# APPLICATION BY NATIONAL HIGHWAYS FOR AN ORDER GRANTING DEVELOPMENT CONSENT FOR THE A66 NORTHERN TRANS-PENNINE PROJECT

Submission on behalf of Cumbria & Lakes Joint Local Access Forum in accordance with Deadline 1 (18 December 2022).

Drawing Title  
**Land Plans  
Regulation 5(2)(i)  
Sheet 3 of 4**

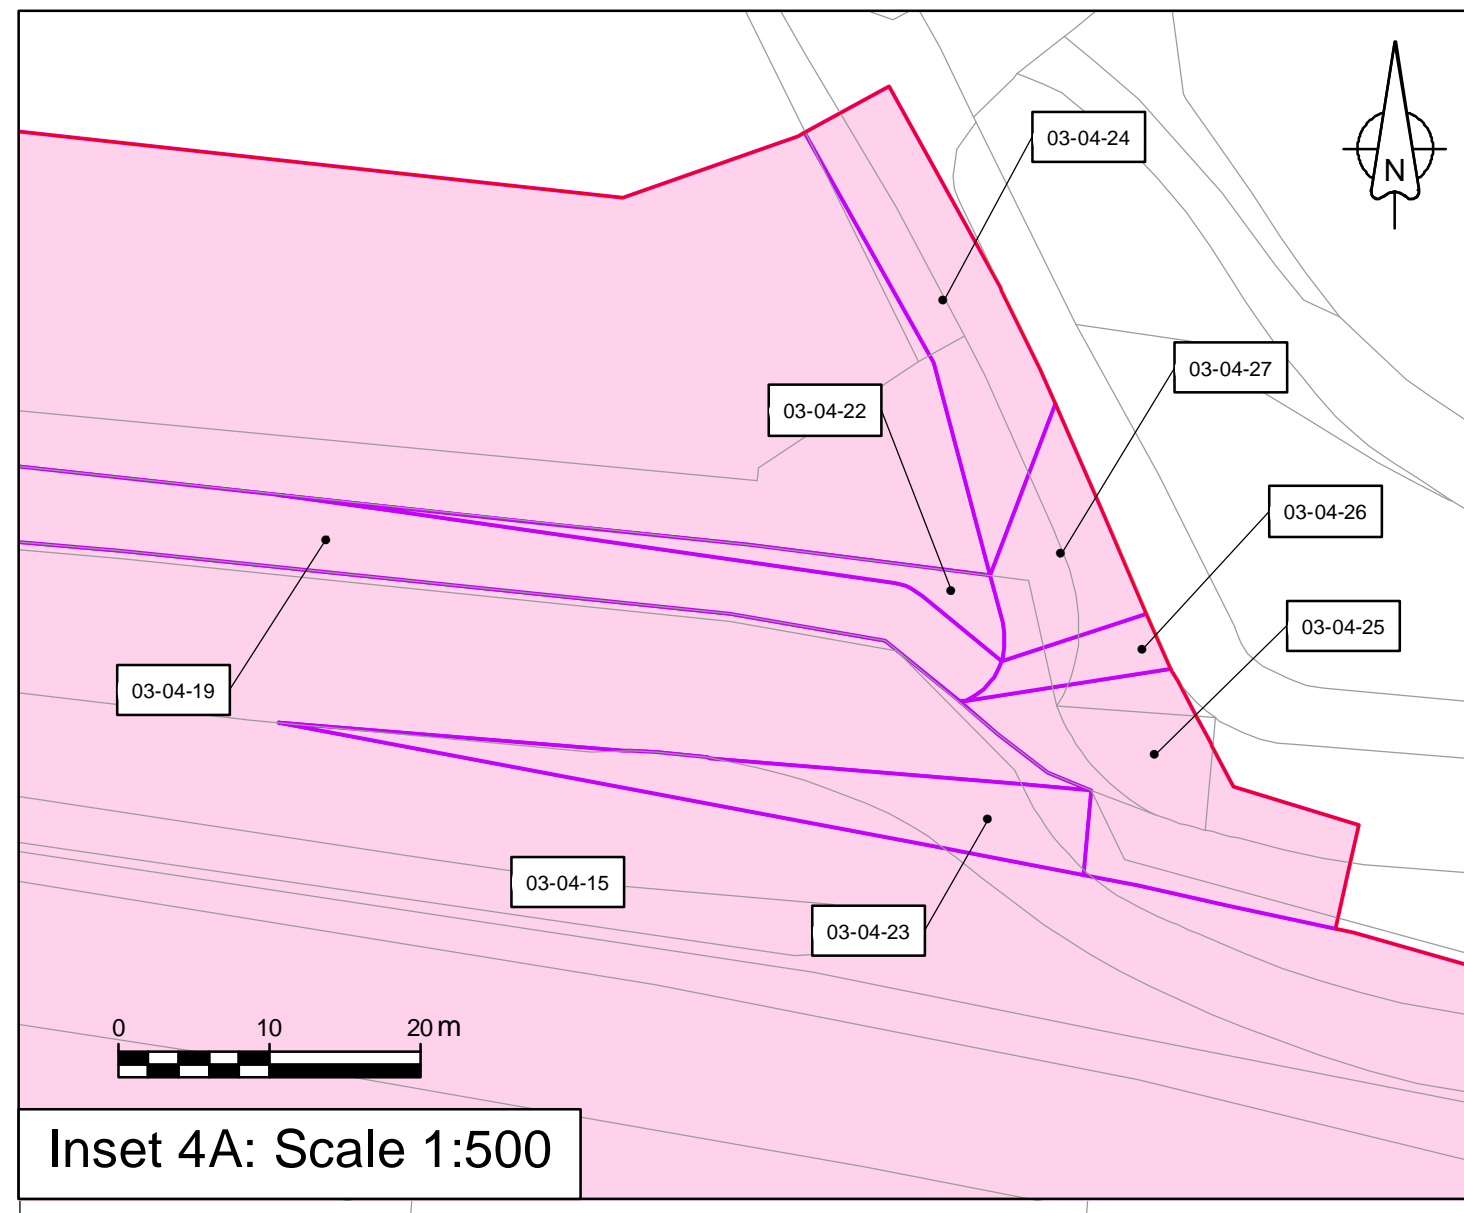
- 9.3 On sheet 3 of scheme 3 there appears to be an error in the description of A\* which refers to a 'shared cycleway' with references to High Barn which possibly are wrongly orientated. And what happens at B\* where there is a section or 'shared cycleway' with no notation.
